**From:** Ian Stocks [REDACTED] **On Behalf Of** FRS Water and Access  
**Sent:** 08 December 2021 15:04  
**To:** Planning.Responses <Planning.Responses@arun.gov.uk>  
**Subject:** Planning consultation - BR/252/21/PL 65-71 Upper Bognor Road Bognor Regis PO21 1HR

Having viewed the plans submitted for planning application BR/252/21/PL for the alterations to four listed buildings, extension of a listed building to create an office and warden's accommodation, erection of new building consisting of 3 No. flats, offices and workshops, evidence is required to show access to all parts inside all flats is within 45 metres of a fire appliance in accordance with the requirements of Approved Document B: Volume 1 2019 edition B5 section 13. It is unclear how close a fire appliance can get to the new build and the distance to the furthest point in each flat.

Drawing
Site Plan As Proposed

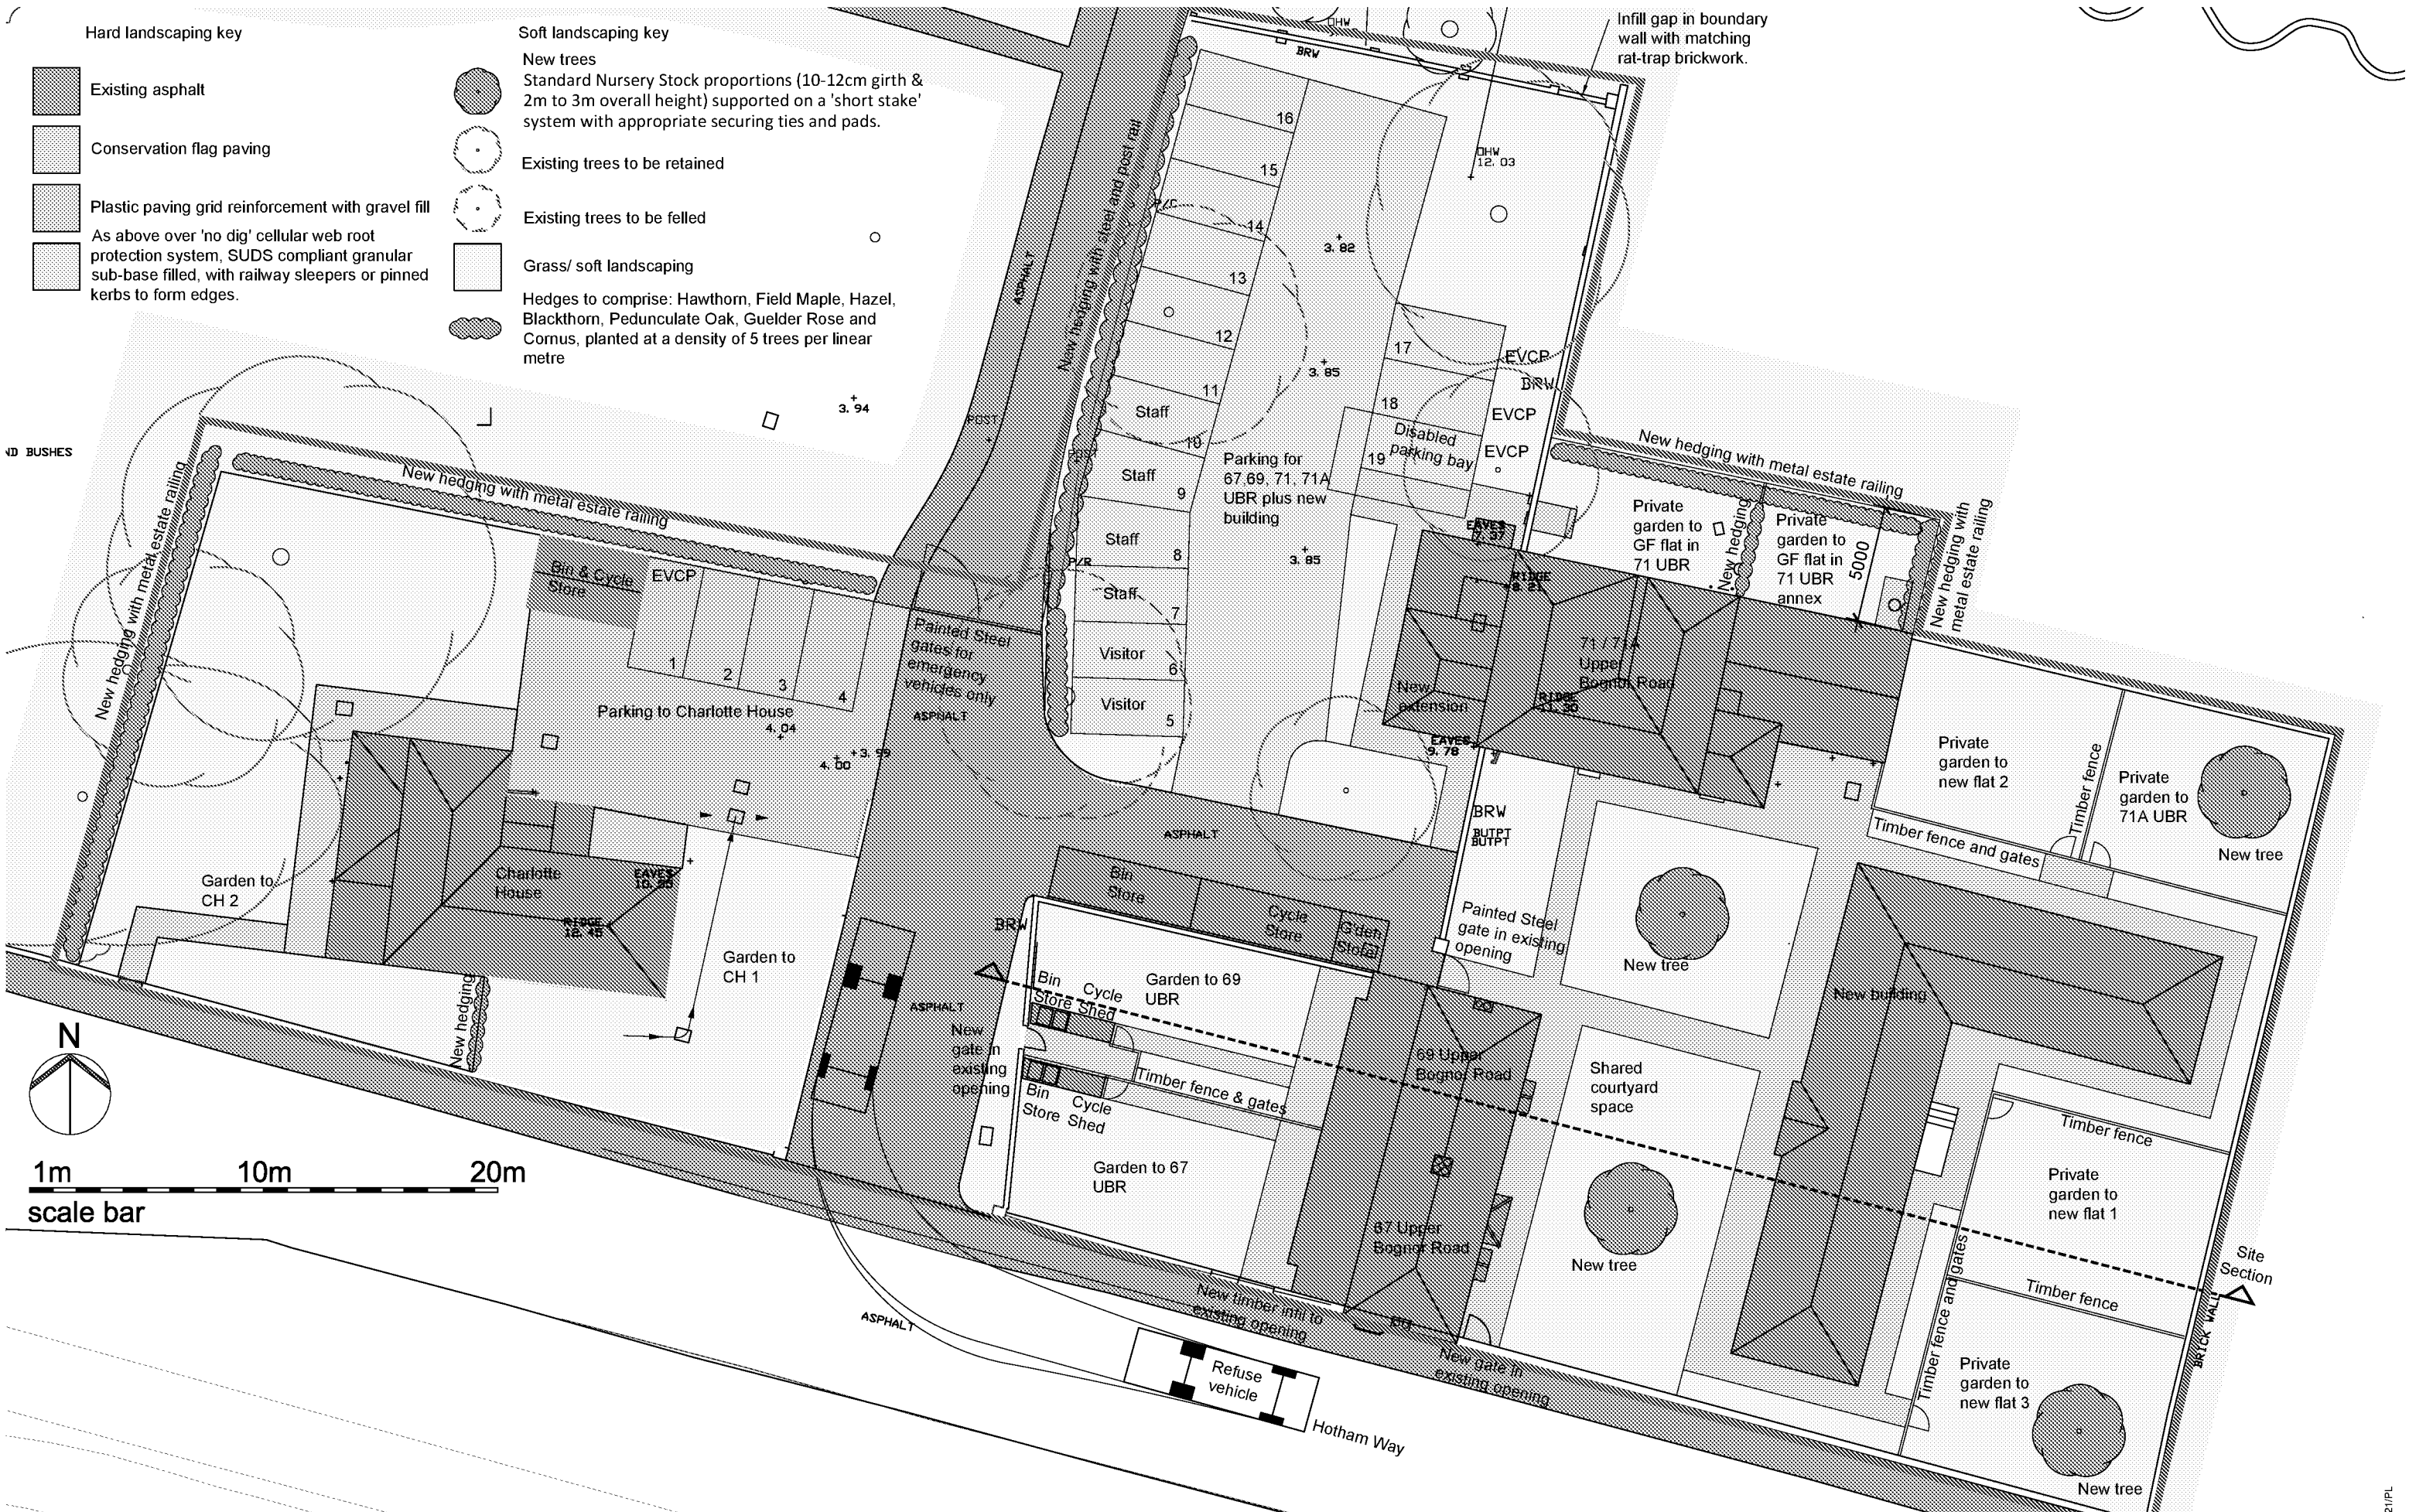
Any areas not within the 45 metre distance will need to be mitigated by the installation of domestic sprinkler or water mist system complying with BS9251 or BS4854 standards.
